Re: Re-submission of details to discharge Condition 9 and 27 of planning permission Y/91/17/OUT

This covering letter accompanies the application and supporting documents submitted online through the Planning Portal under the reference: PP-11291128, which relates to the re-submission of details to support the discharge of Condition 9 and 27 of planning permission Y/91/17/OUT at Land at Bilsham Road, Yapton.

Engineers Comments Regarding Condition 9

Drawing Status	CONSTRUCTION		
Client	THAKEHAM		
Project	BILSHAM ROAD YAPTON		
Drawing title	PRIVATE DRAINAGE DETAILS		
Scale	NTS	Date	FEB 22
Drawn By		Checked By	
Drawing No.	D1956-15-3		Rev.
			B

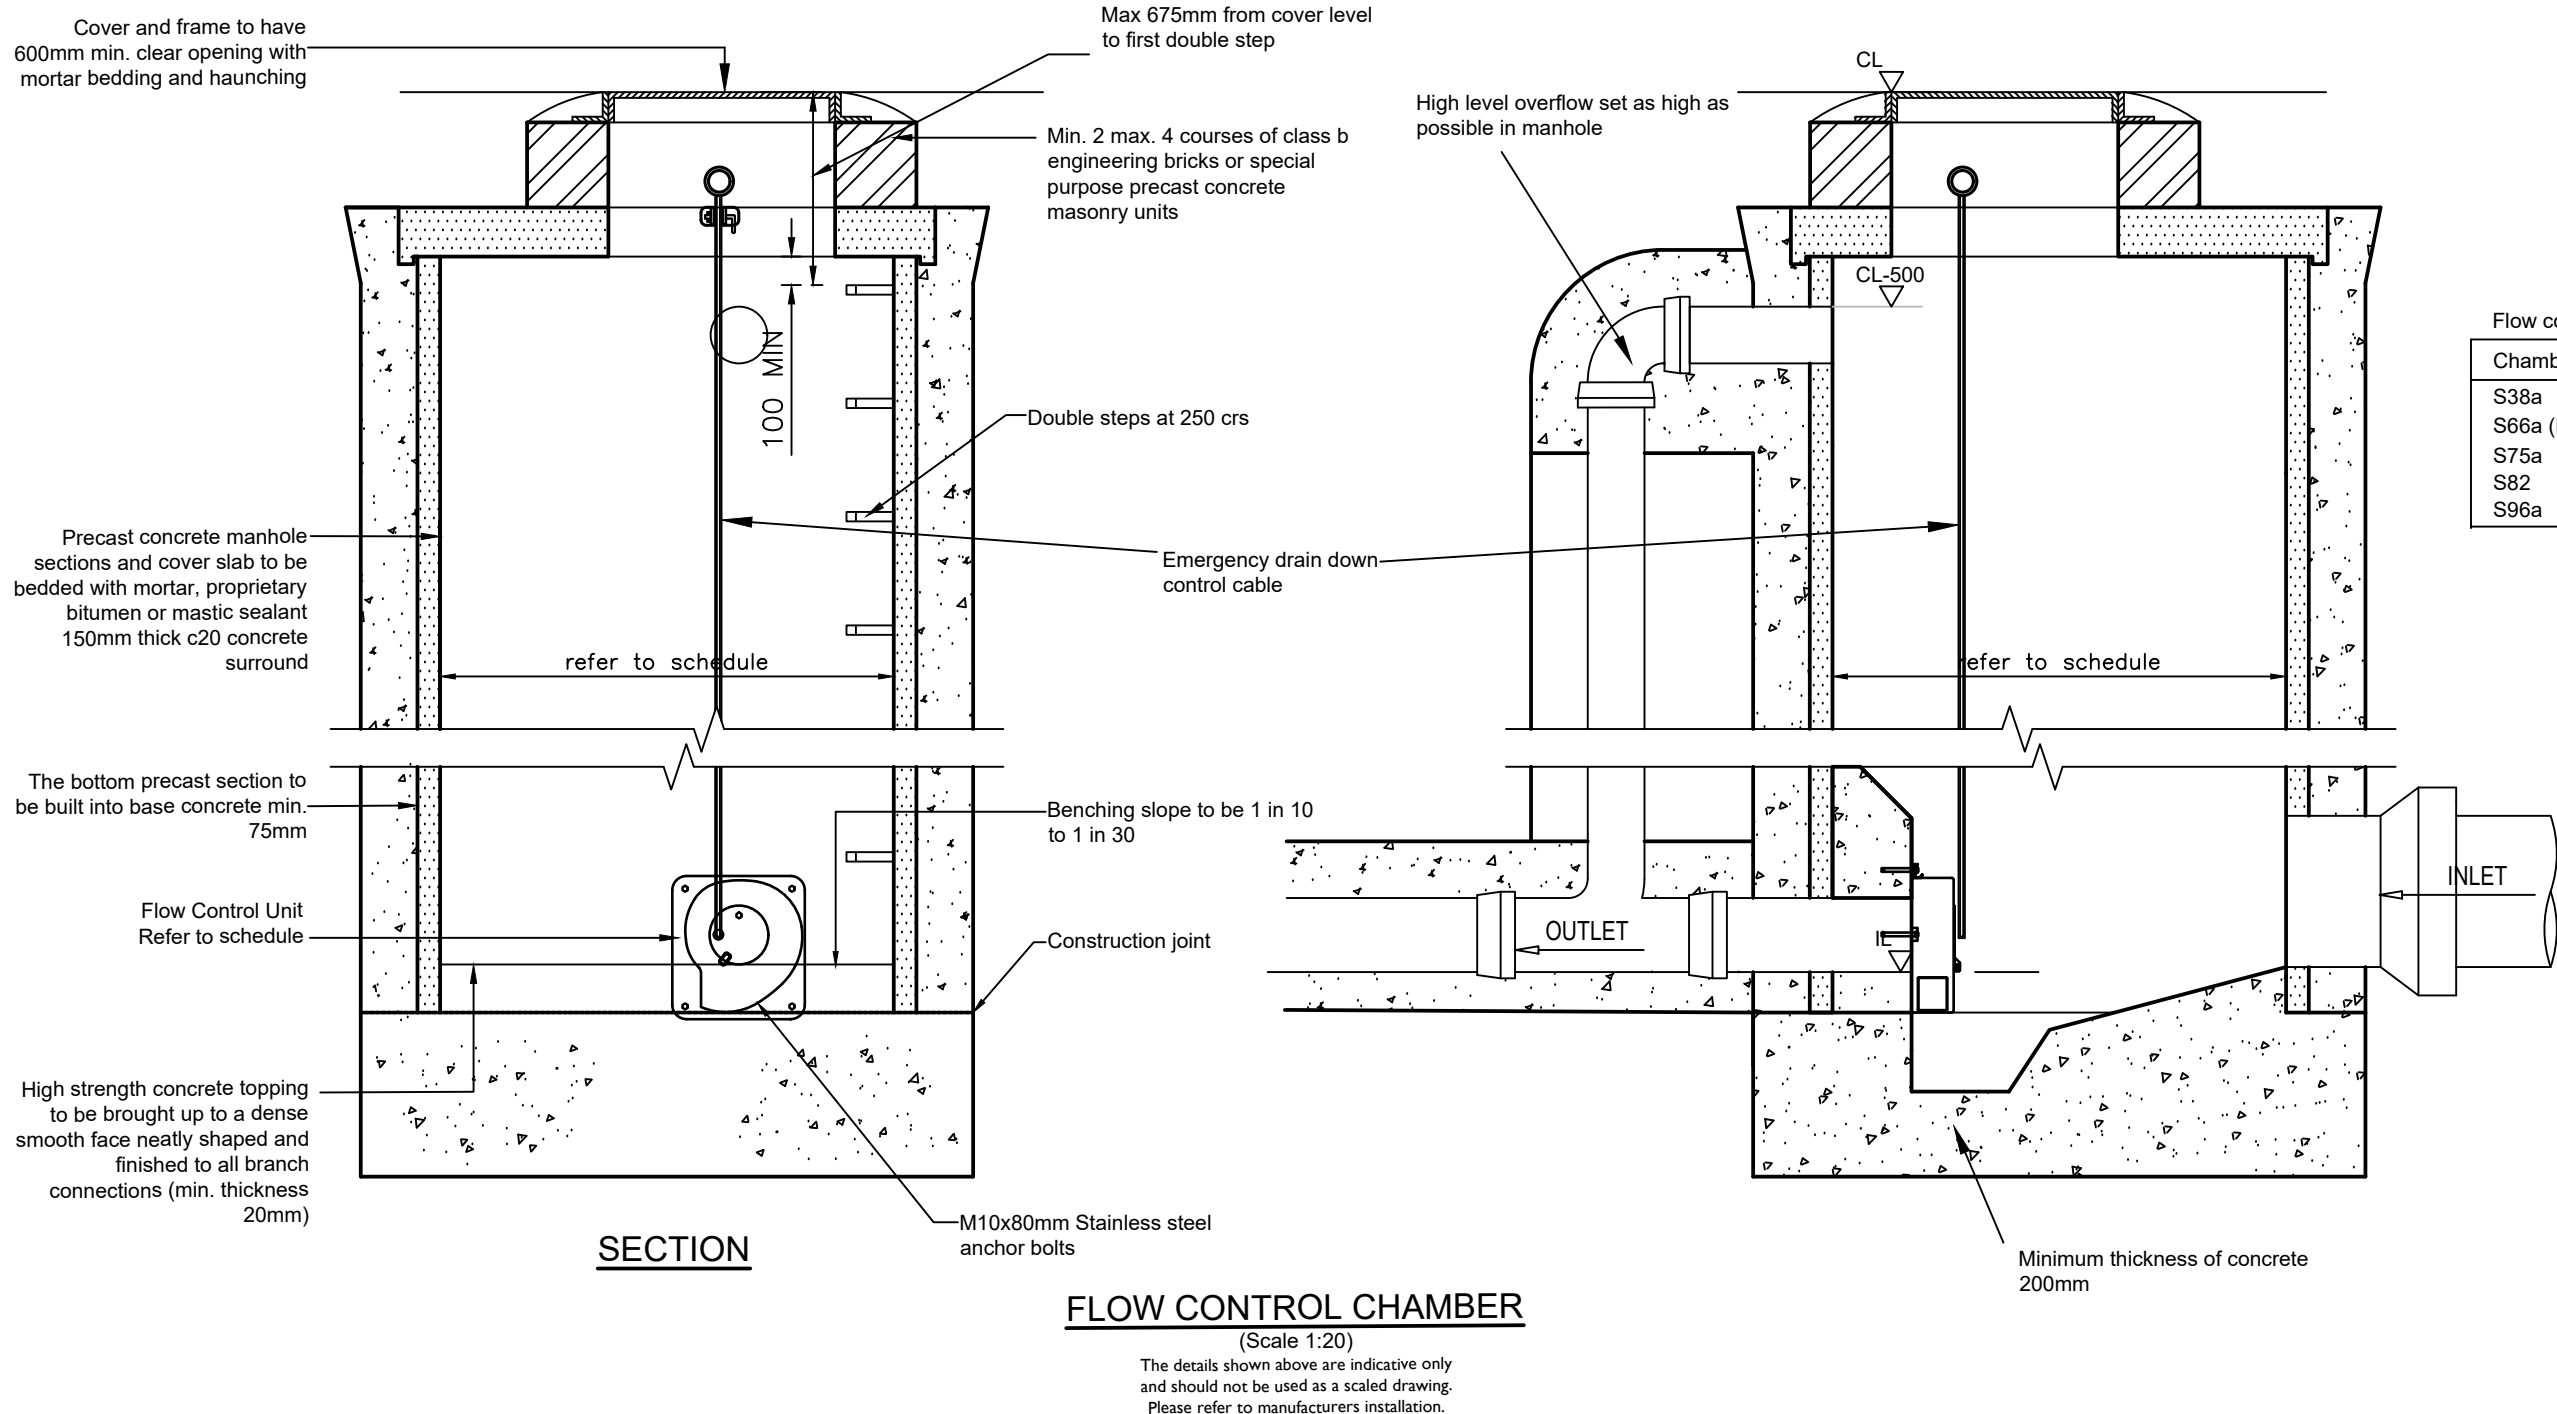
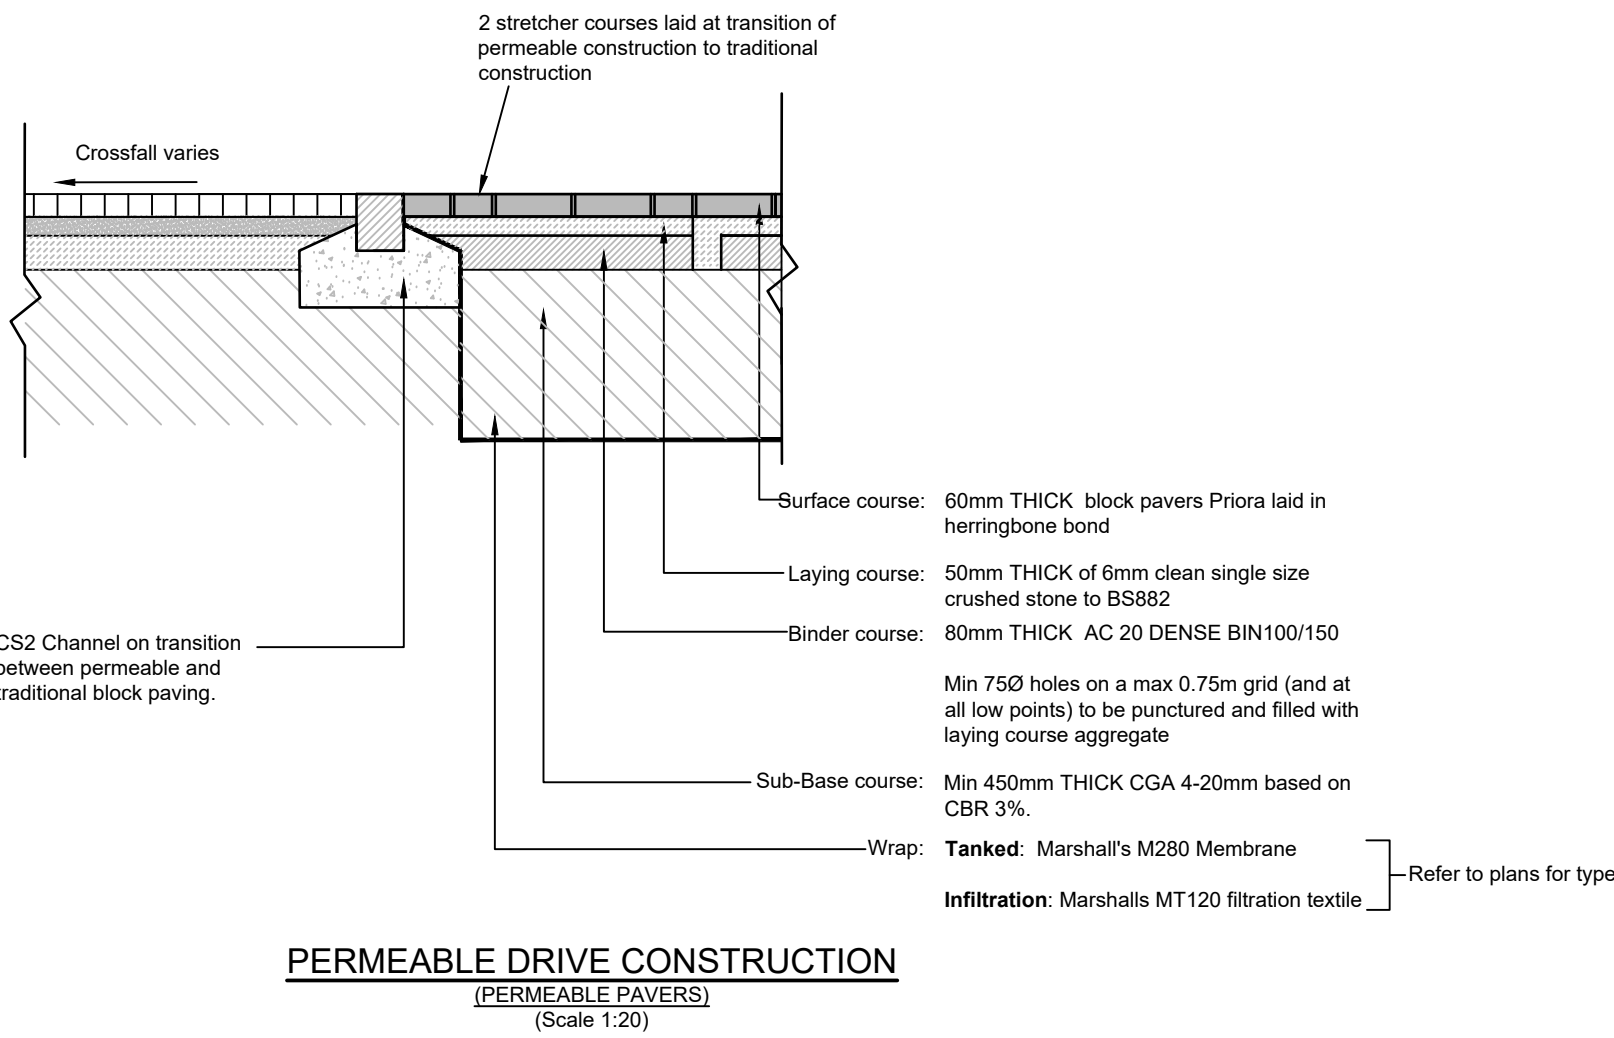
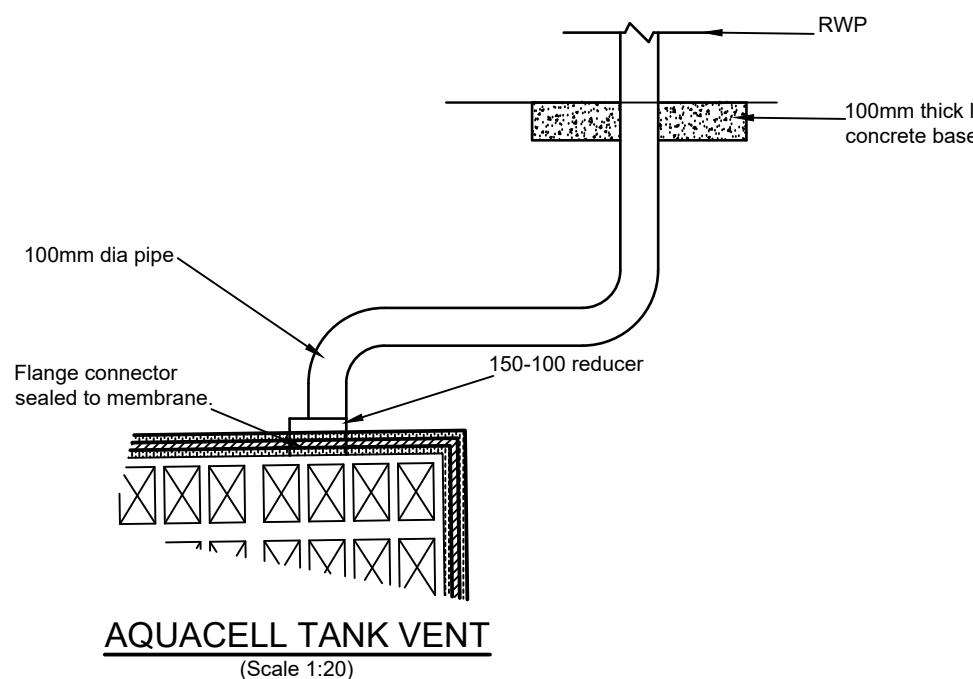
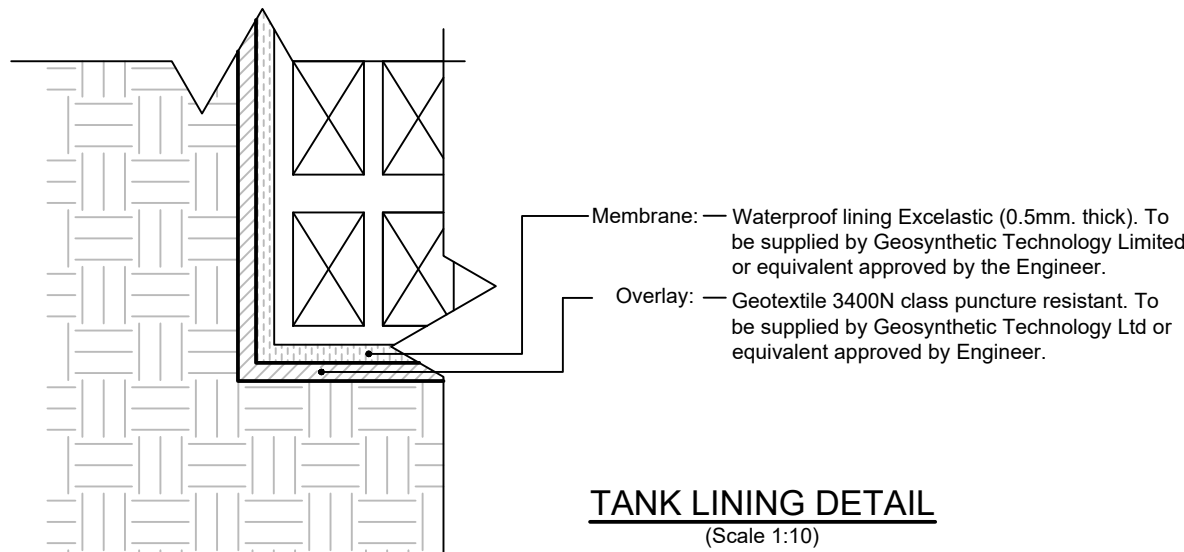
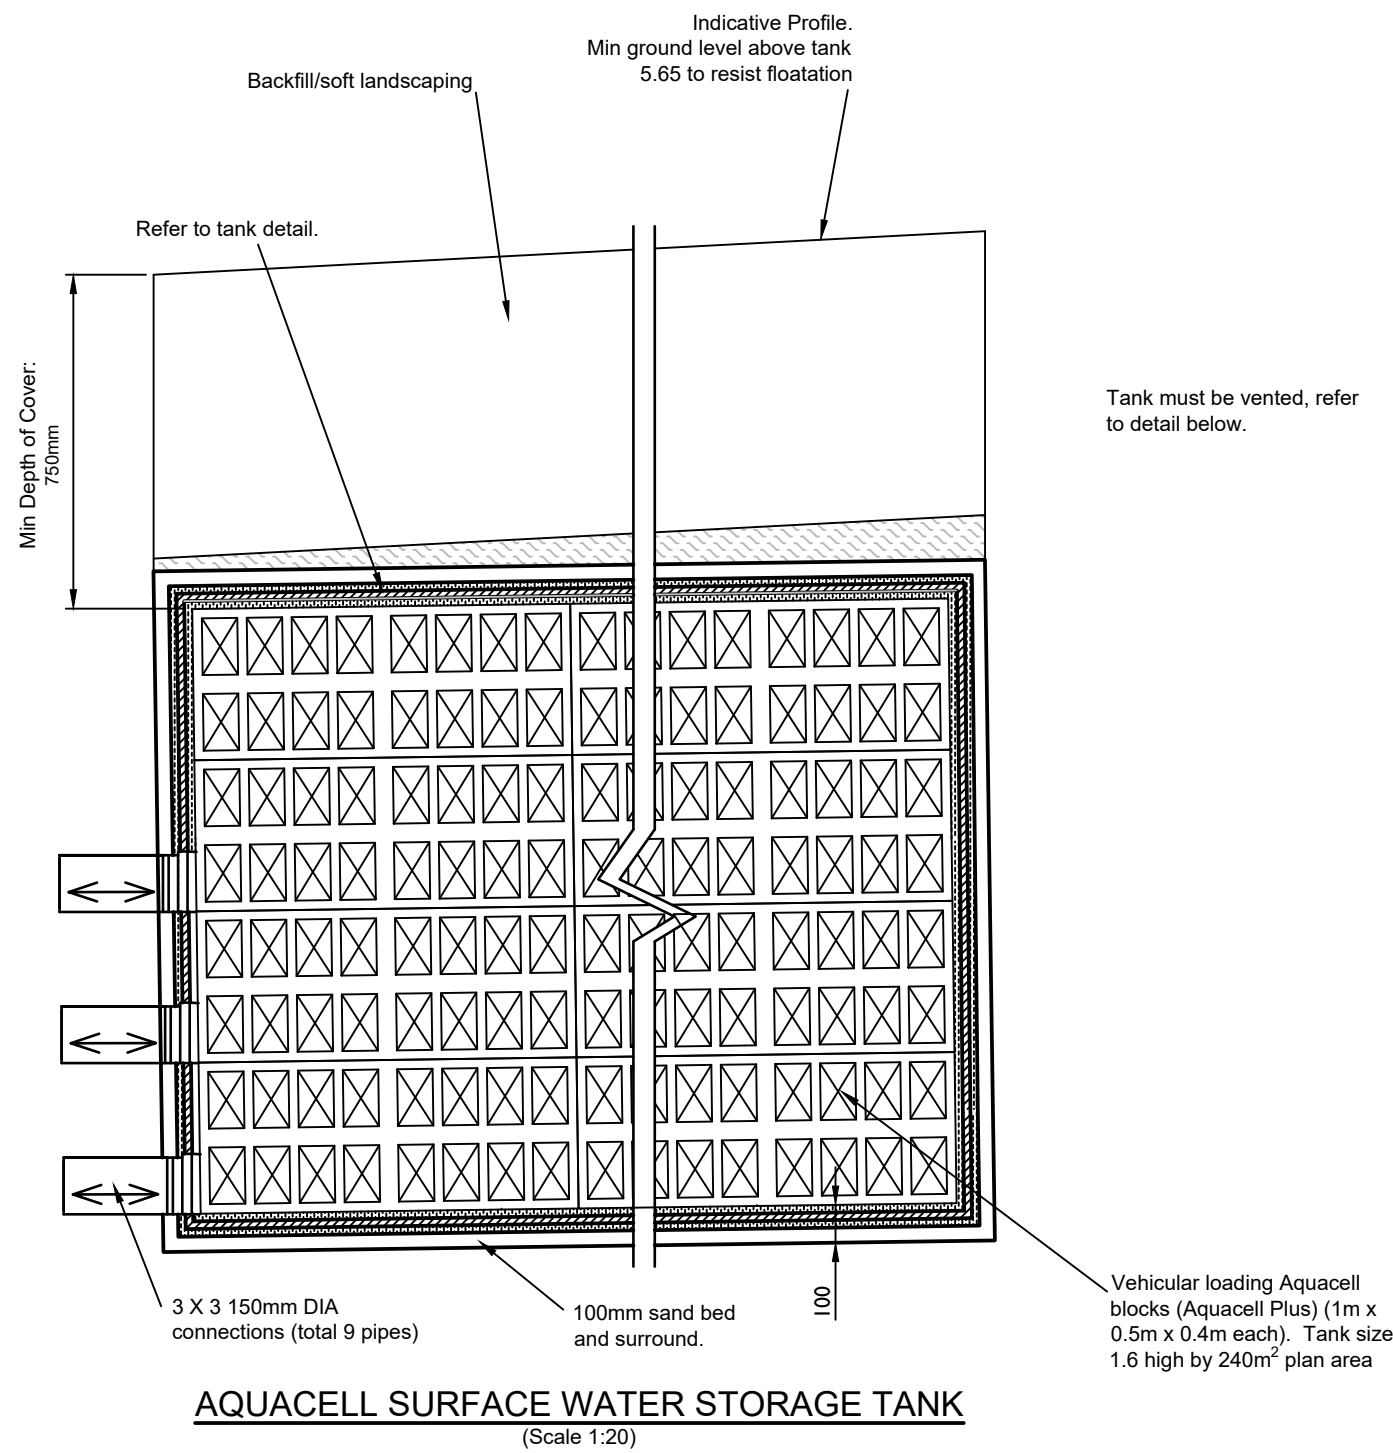
11. Please provide cranked grilles at a 45 degree angle.
12. Please detail invert levels of hydrobrakes and invert levels of overflows for each flow control device on the detail drawing.

16. Please provide a construction detail of permeable paving which clearly defines the construction, i.e. blocks, bedding, membranes, sub-base, tanking membrane. Materials and depths should be clearly defined.

11. Please provide cranked grilles at a 45 degree angle. – This is not DCG compliant.
12. Please detail invert levels of hydrobrakes and invert levels of overflows for each flow control device on the detail drawing. These details have now been added to drawing D1956-15-3A

16. Please provide construction detail of permeable paving which clearly defines the construction, i.e. blocks, bedding, membranes, sub-base, tanking membrane. Materials and depths should be clearly defined. – This has been added to drawing D1956-15-3A.
